**From:** Simon Davis <Simon.Davis@arun.gov.uk>  
**Sent:** 29 January 2021 10:53  
**To:** Planning.Responses <Planning.Responses@arun.gov.uk>  
**Subject:** Cinders Nursery Phase 2 ref Y/140/20/DOC

Final drainage comments

**Subject:** RE: Cinders Nursery Phase 2, Cinders Lane: Planning Consent Y/32/17/OUT

Appendix A Field Work

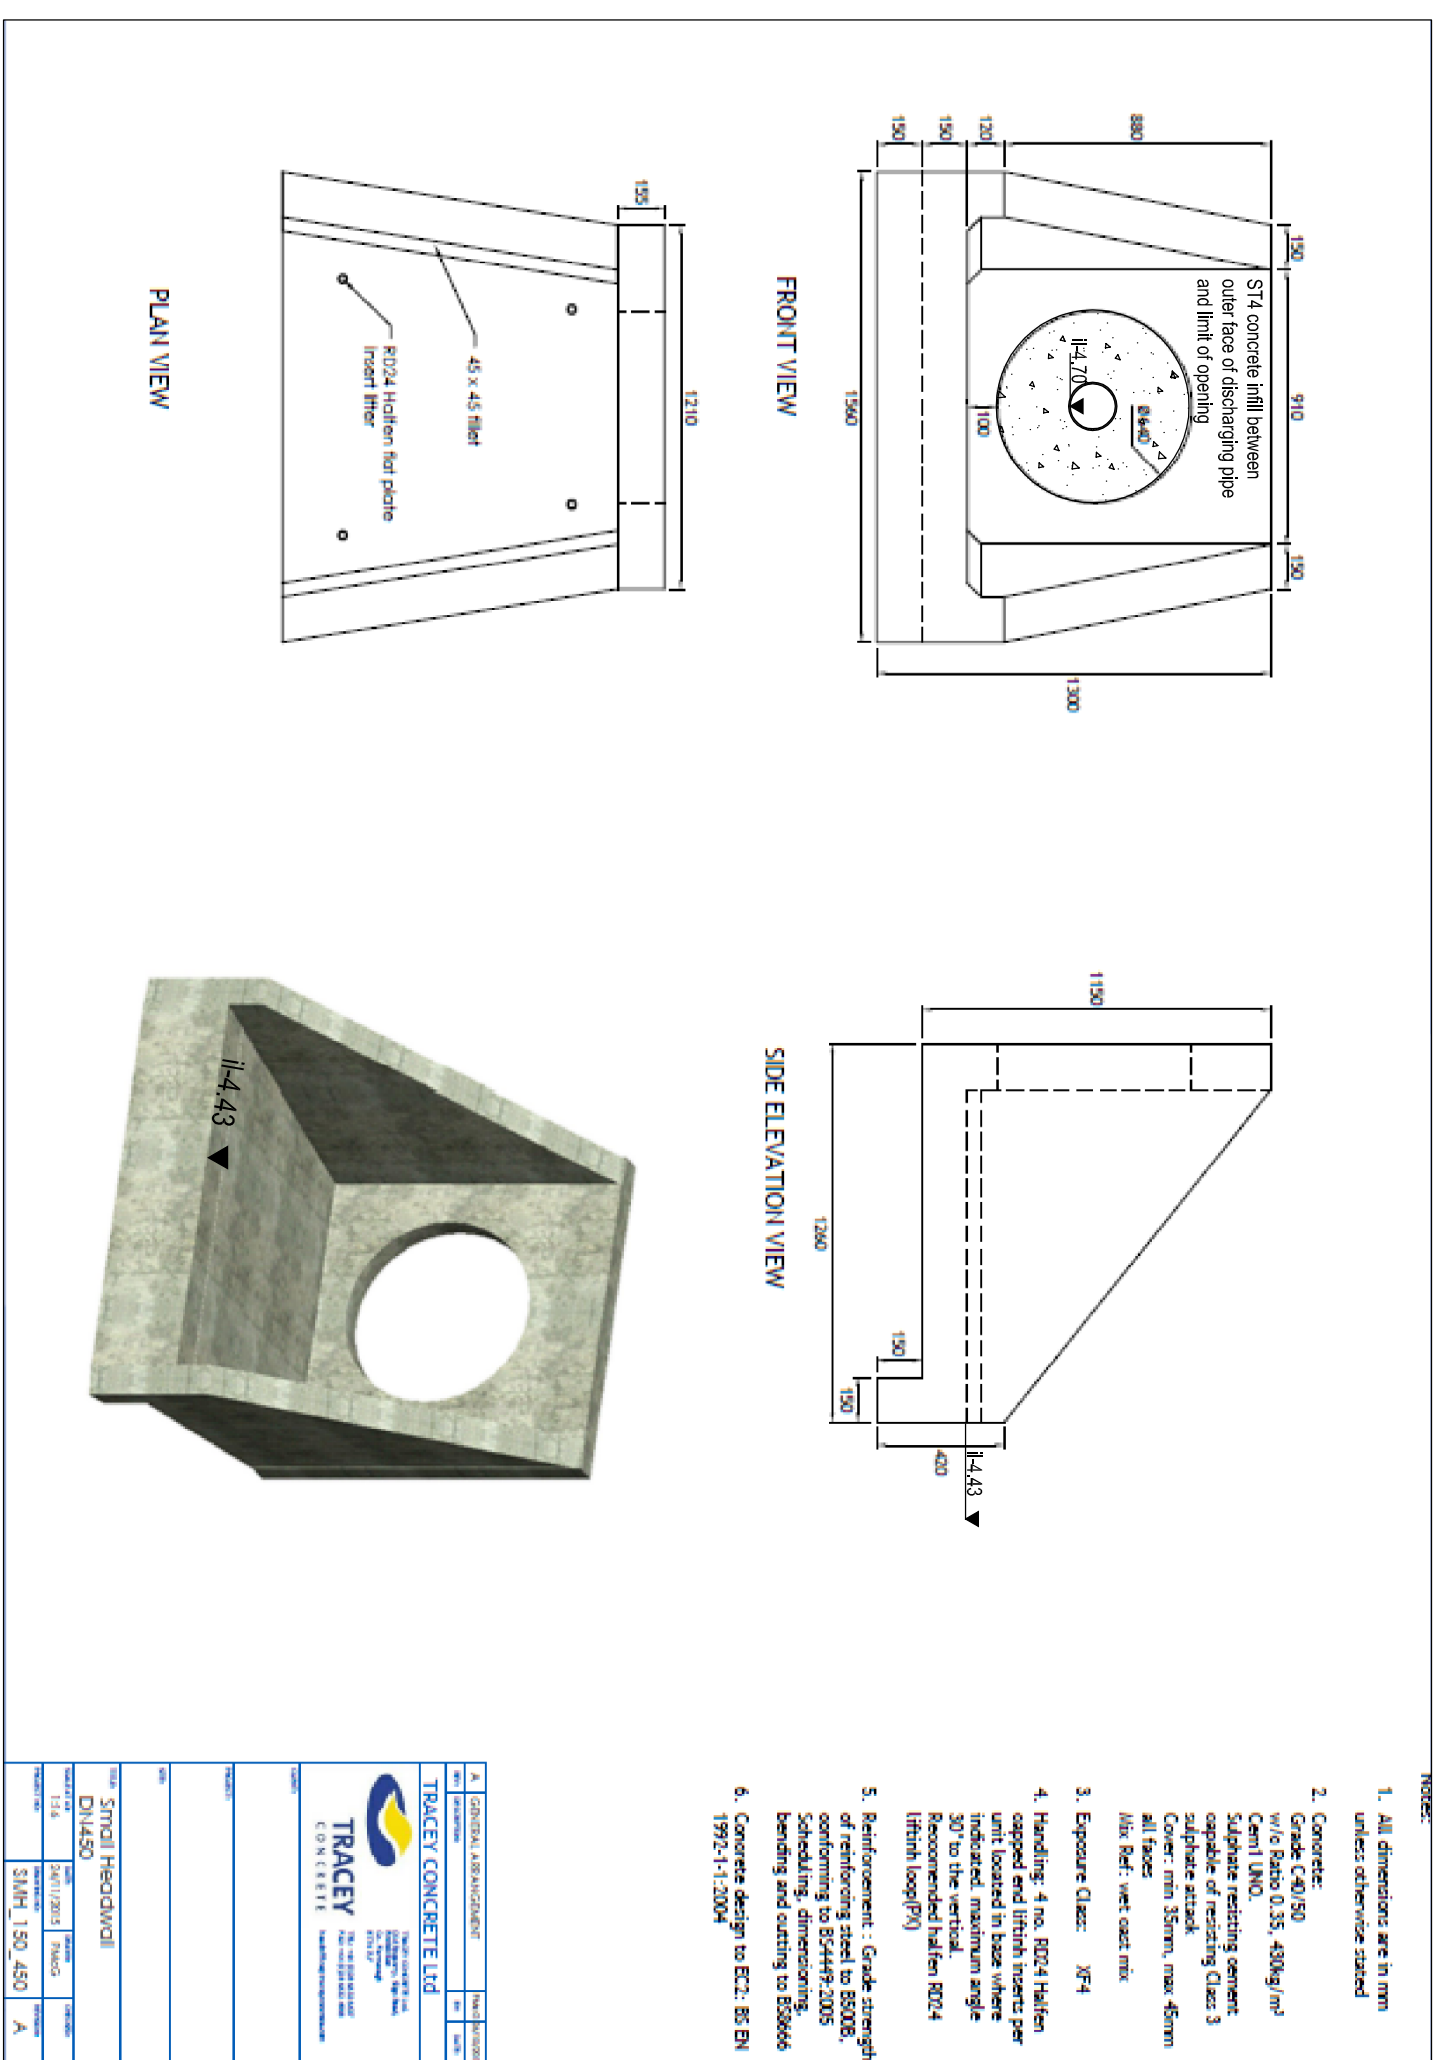
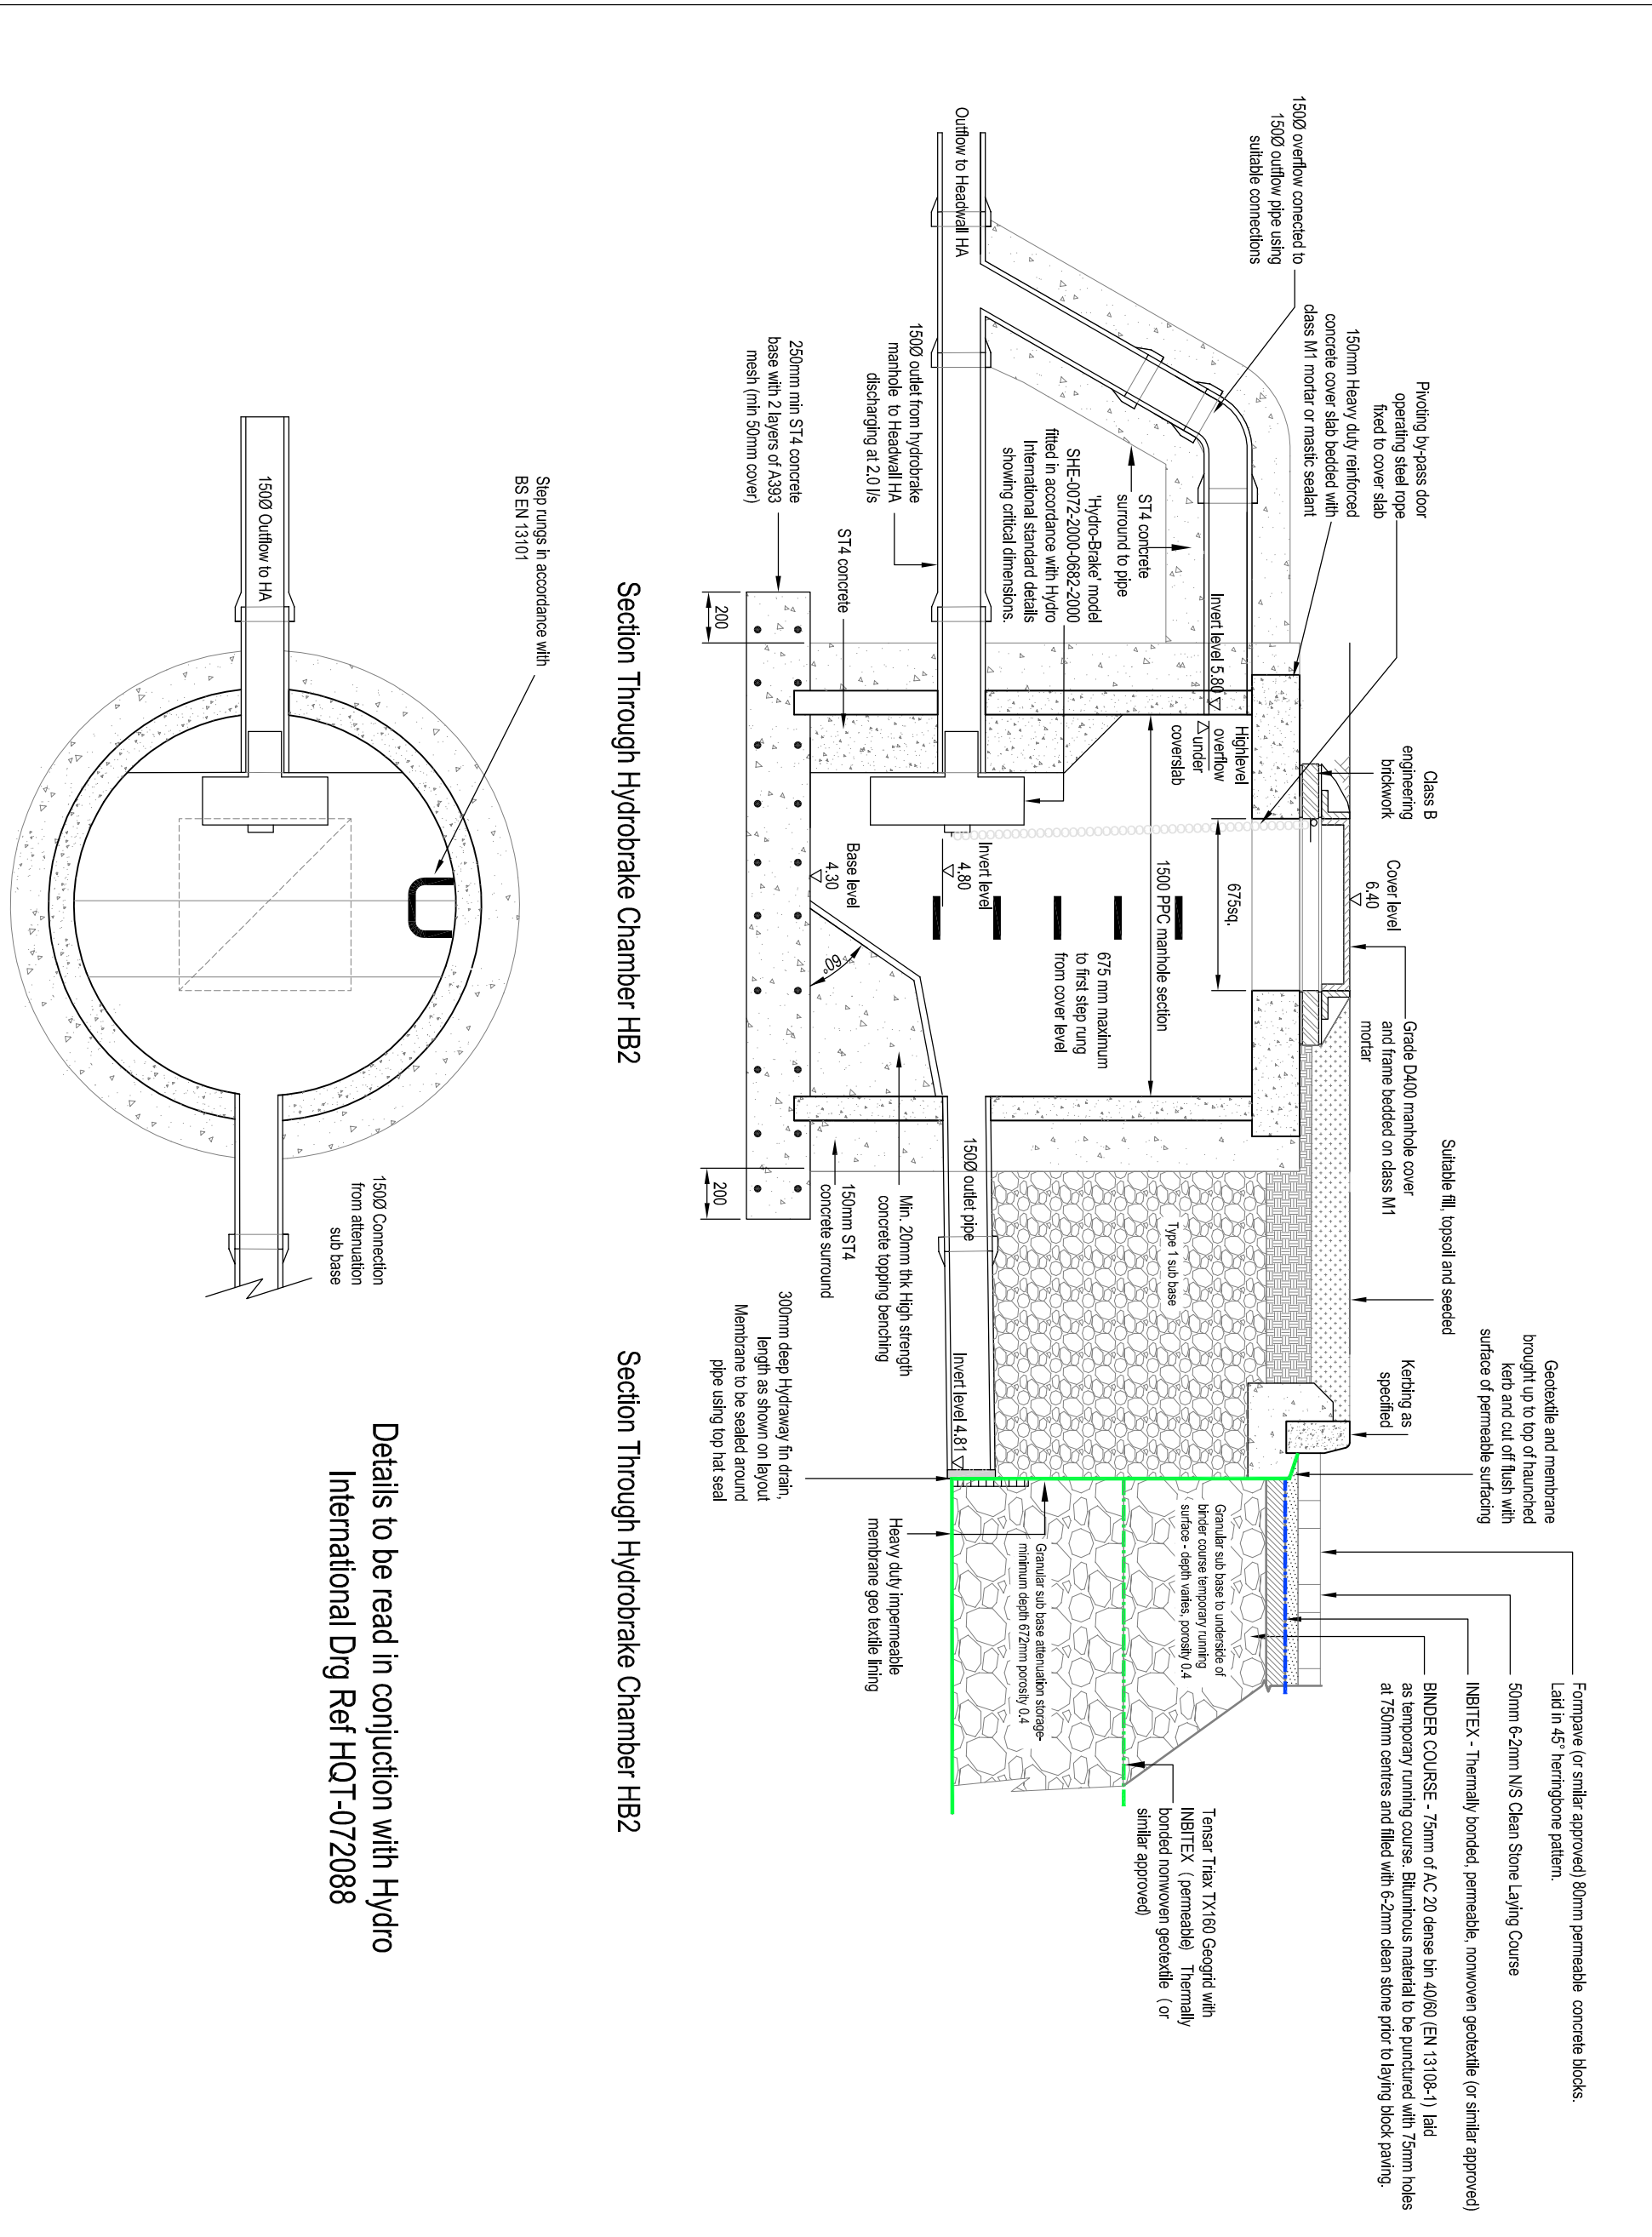
2. Show ditch bed levels at headwall and downstream on plan. Levels shown on drg KNC2006-502-01 Rev F ok
3. Manhole/headwall schedule shows the HA headwall as type H1 – label headwall construction detail as H1. This headwall has now been named H2 to avoid any confusion with other headwalls on the earlier phase. ok

6. Shorten the concrete apron to prevent it extending below the ditch bed. To terminate at the toe of the bank. This will allow the farmer to adjust ditch bed levels as necessary in the future. I have realised that the OWC for the previous phase approved the Tracey Concrete Standard Small headwall which is shown on the approved drawing KNC1826-501-04 Rev D. For continuity I am advocating the use of this headwall for the Phase 2 discharge so I have substituted this for the previously proposed brick construction headwall designated type HA. I trust this meets with your approval. ok
